2190140

**RE: RESPONSE TO REQUEST FOR ADDITIONAL INFORMATION
(SSD 7317 – MOD 19 – PRECINCT MARKER SIGNAGE)**

Ethos Urban has prepared this letter on behalf of Mirvac Projects Pty Ltd (Mircac) in response to the Department's request for additional information, dated 9 October 2020.

Precinct Markers: Location 4 / Concept 1

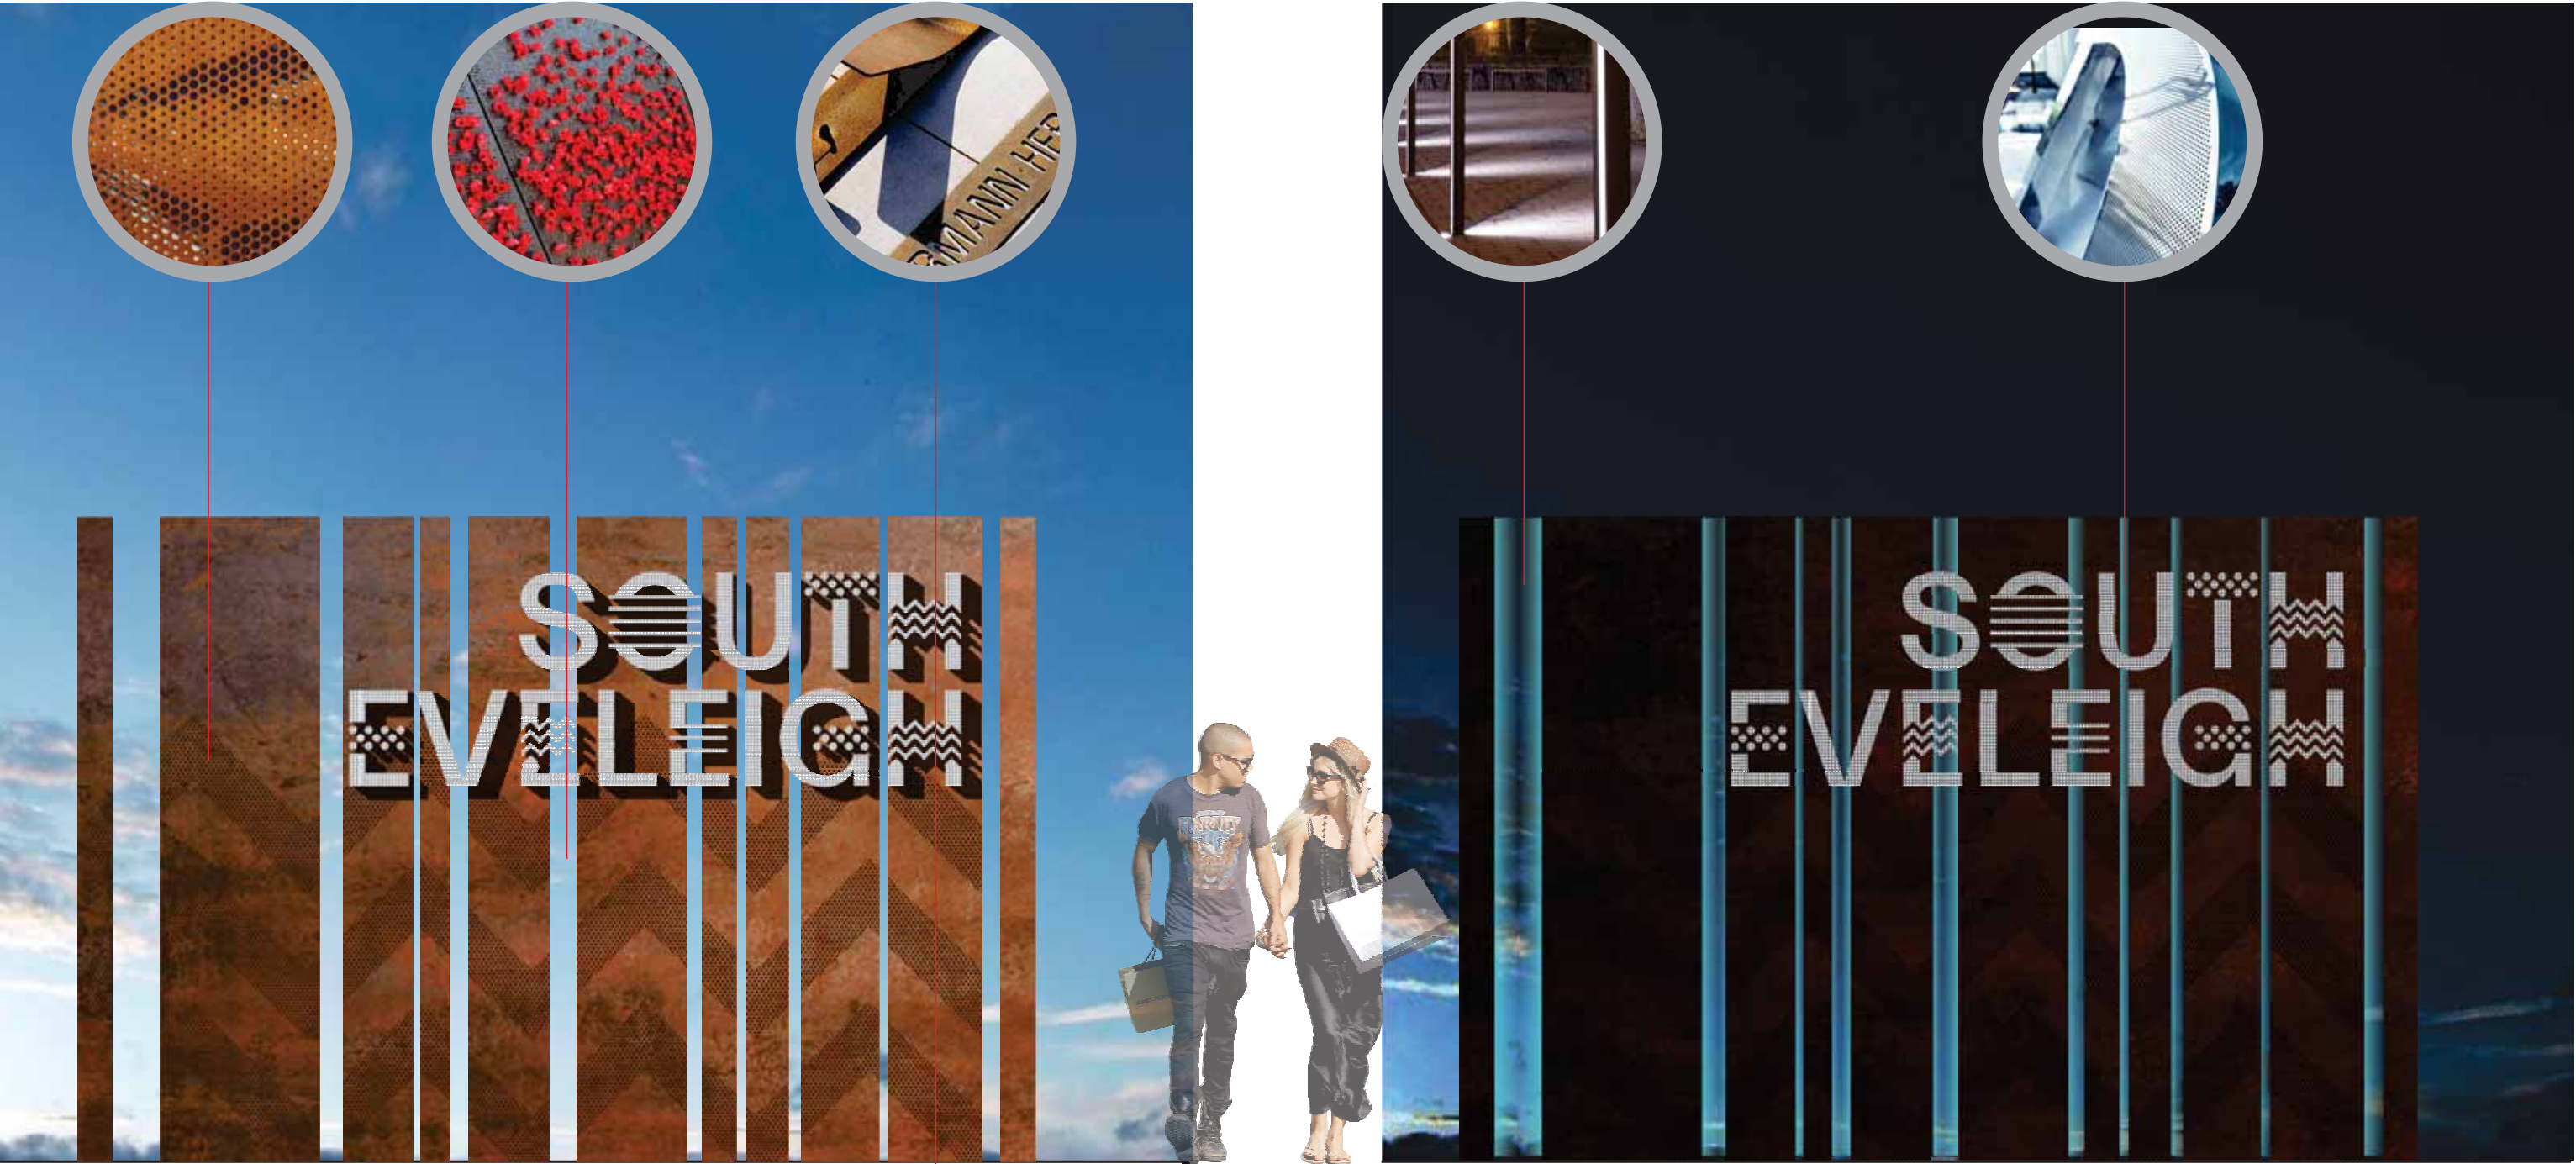
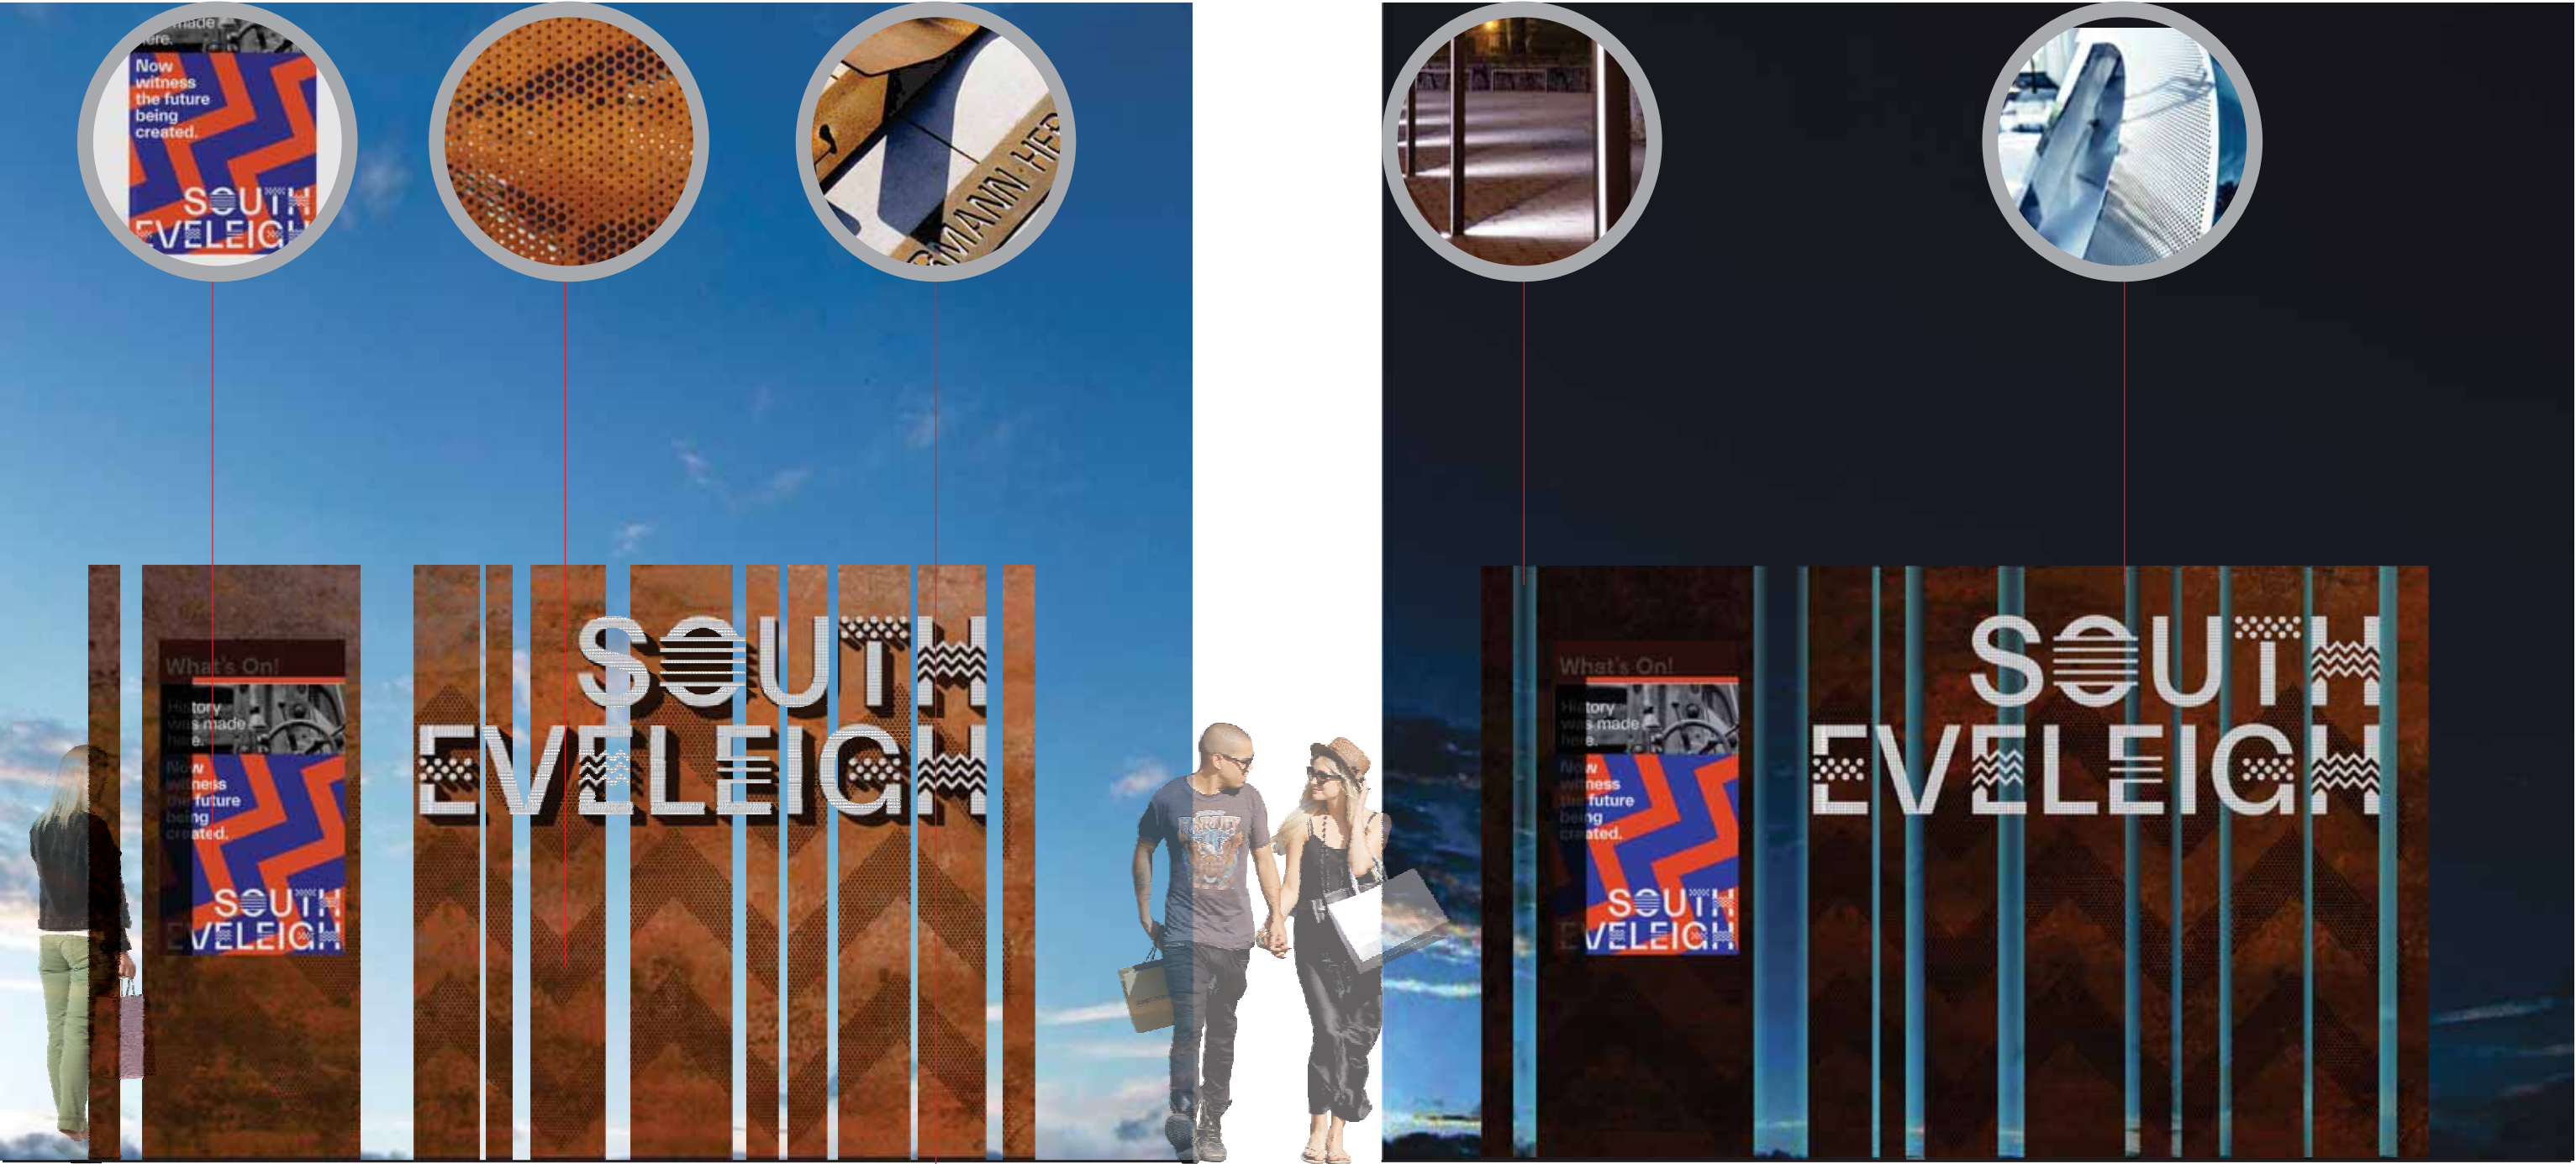
Please provide a response to Council's comments regarding the Redfern Station sign and concerns about blank areas of concealment and options to increase permeability and visibility through the sign.

Further consideration should be made to reduce the blank areas of concealment so as to increase permeability and visibility through the sign. Specifically, the concealed portion of the panel beneath the digital screen should be made permeable. This is to discourage opportunities of anti-social behaviour and ensure the safety of passer-by's traversing to and from the precinct.

Additional design amendments have been made to the proposed Redfern Station sign to increase the permeability of the design. The original design that included only gaps between the columns provided 80% the mass of a solid wall. As shown in the updated drawings, the perforated zig zag pattern is to incorporate hole sizes of between 5-10mm in diameter that will be 40% open to the rear and a 70% open perforated pattern to the front representing 50% of the mass of a solid wall.
